DECISION DELEGATED TO HEAD OF PLANNING

Application No: H14-0224-24 **Applicant:** Cecil Francis Ltd

Proposal: Details of surface water disposal, external materials, external doors/door frames, window frames and gas/electricity boxes (Conditions 9, 14, 15, 16 and 19 of H14-0706-22)

Location: Cecil Francis Ltd Bear Lane Pinchbeck

South West Elevation (rear)
Scale 1:50

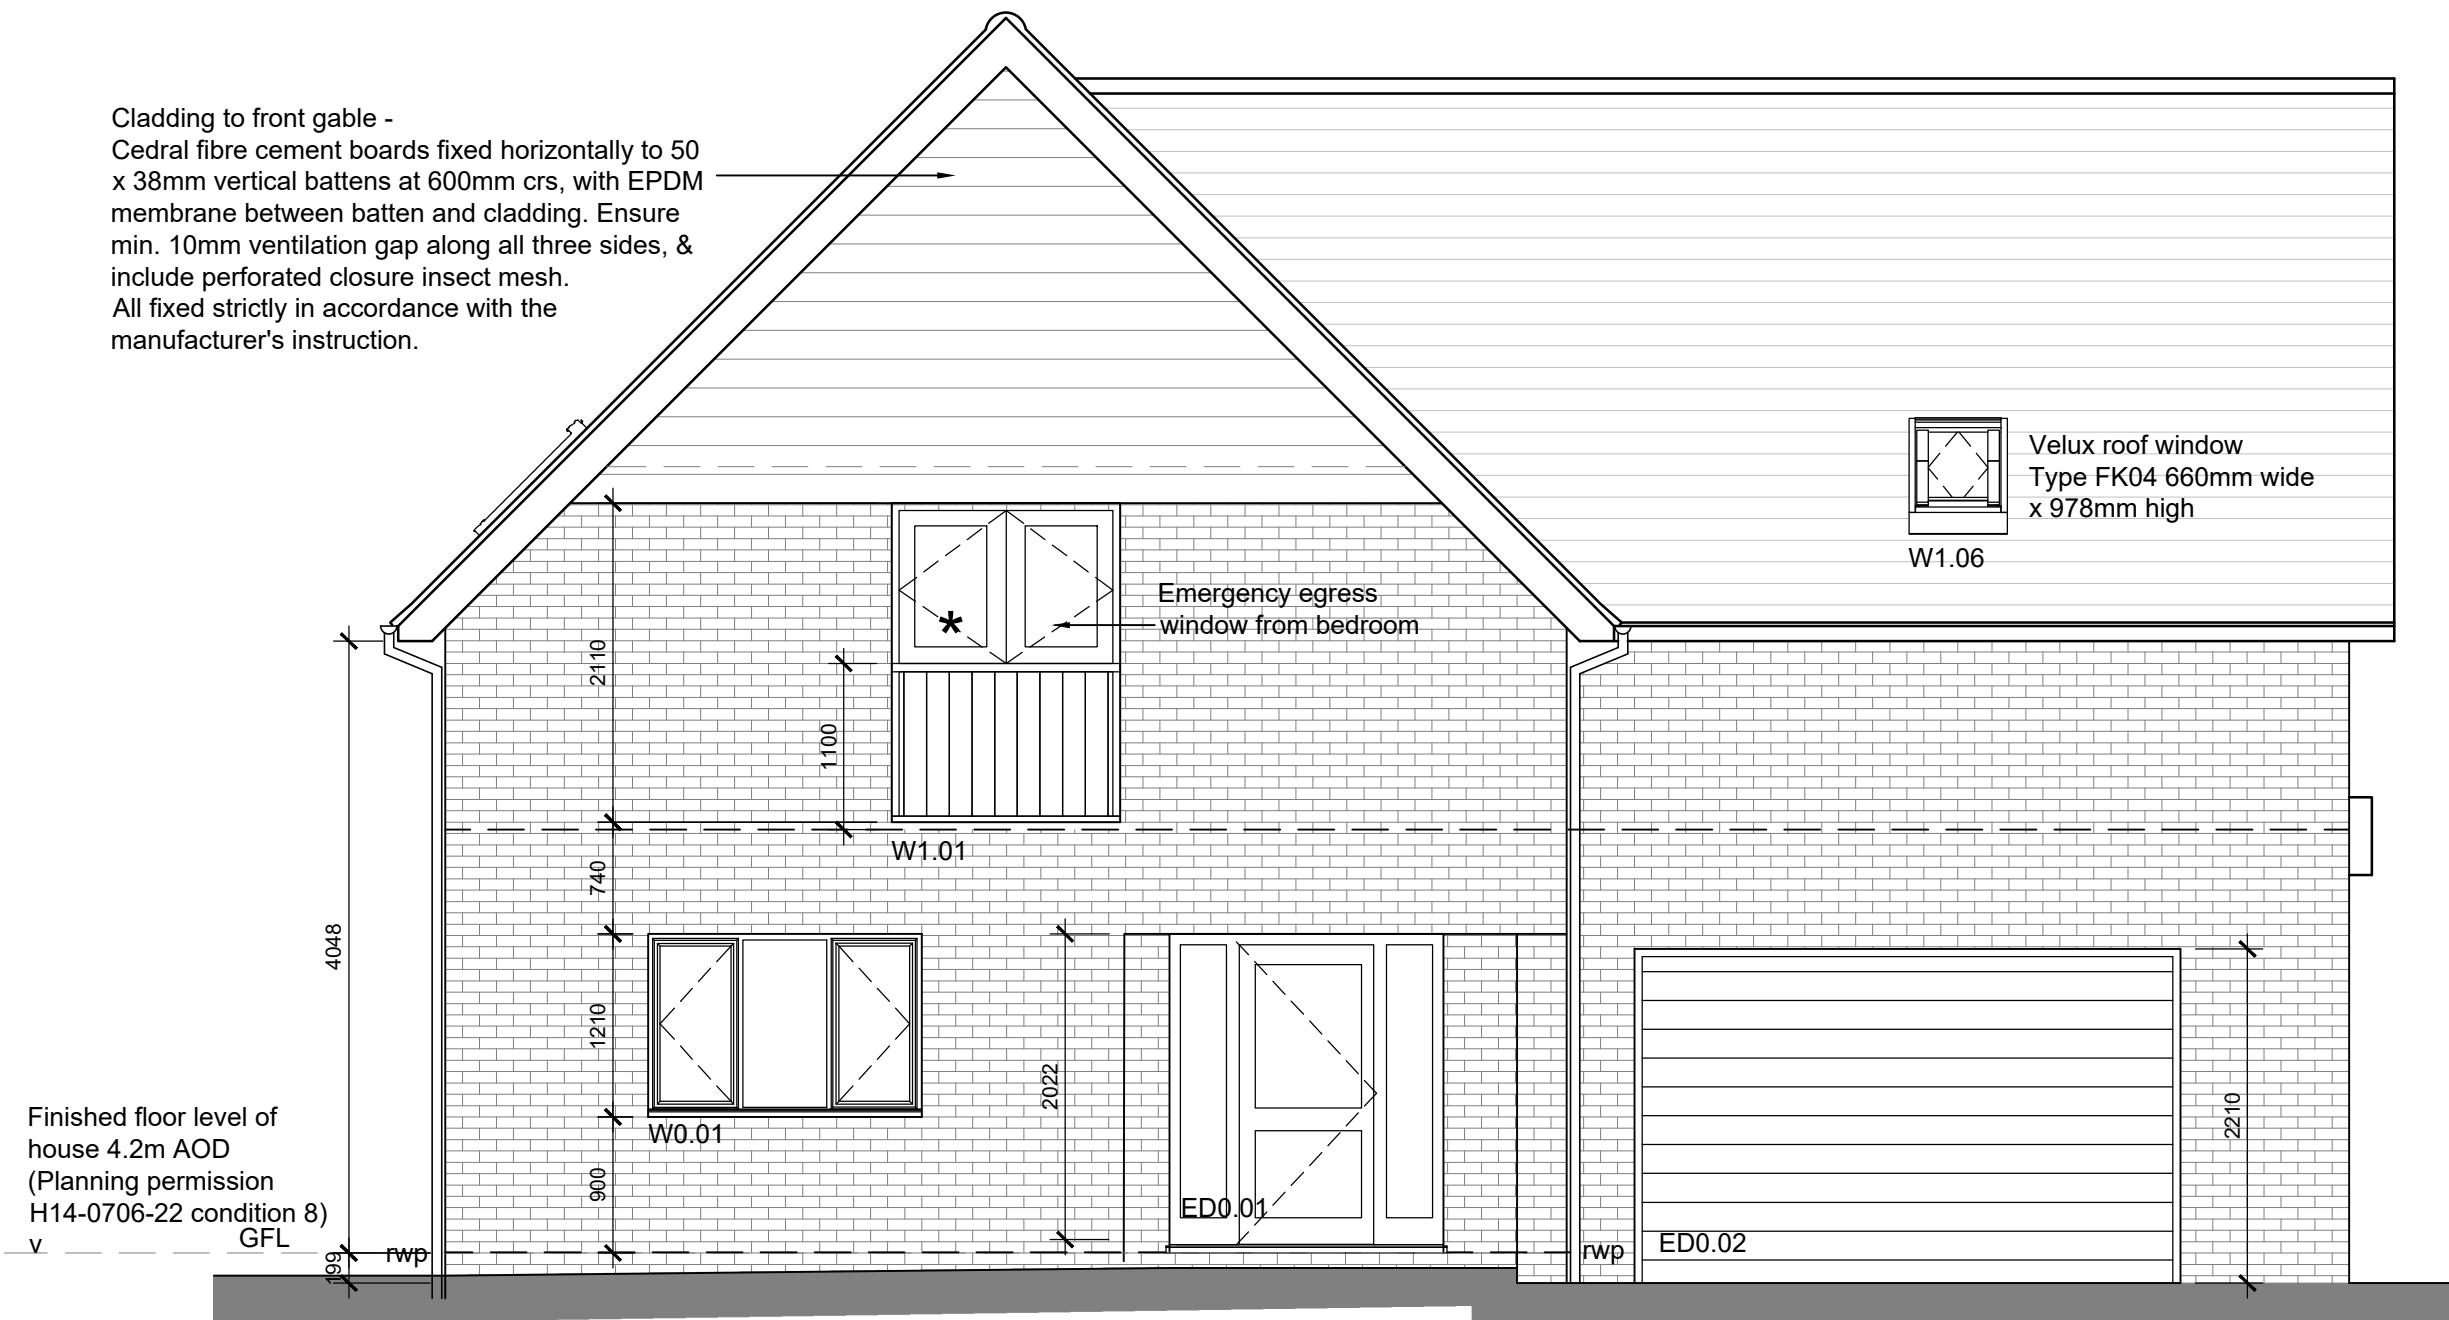
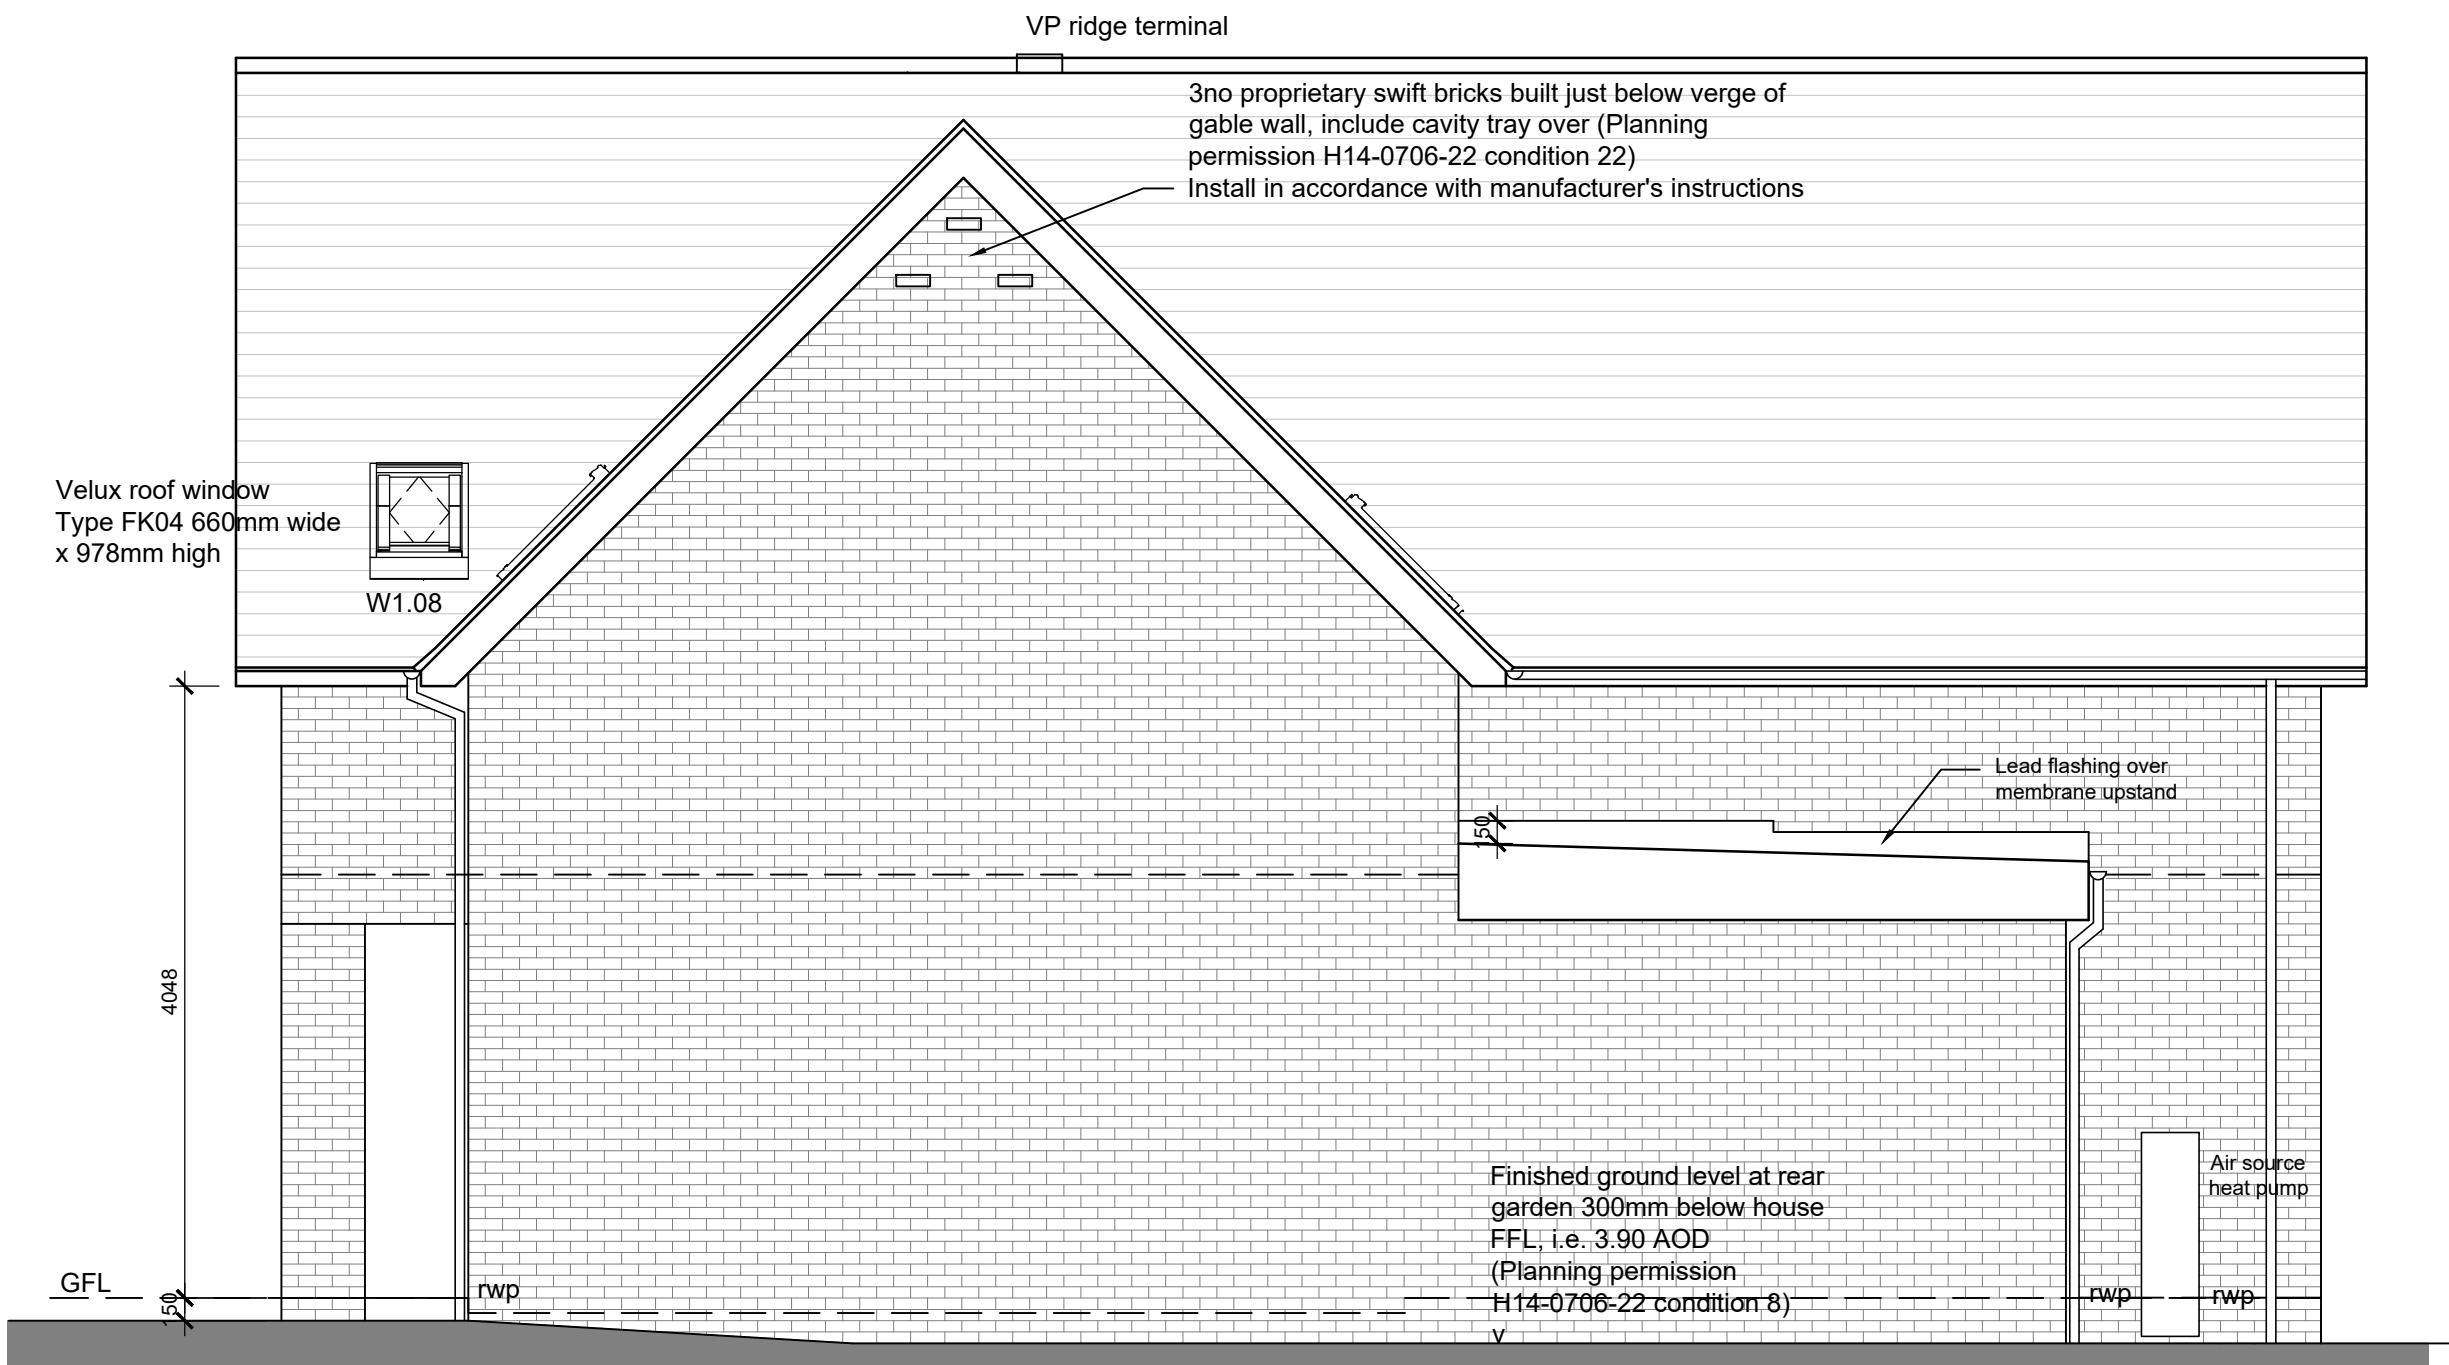
For Plot 2, a door is proposed on the south east elevation. The rear elevation (south east elevation) shows sliding patio doors. For Plots 1 and 3, on the south west elevation, there are rear patio sliding doors. The north west elevation has at ground floor level.

The submitted details for Plot 2 shows a velux type roof window on the north east elevation, a casement window at ground floor and a emergency egress window at first floor from the bedroom. A further velux is shown on the north west elevation.

For Plot 2 the electrical cabinet is shown on the south east elevation. It is a standard cabinet in white. The air source heat pump is shown on the south west elevation in the centre of the site away from neighbours. It only comes in a standard grey colour and is an Ecodan R32 Air Source Heat pump.

The details are considered satisfactory and condition 15 can be discharged.

It is considered that the details are satisfactory and condition 16 can be discharged.
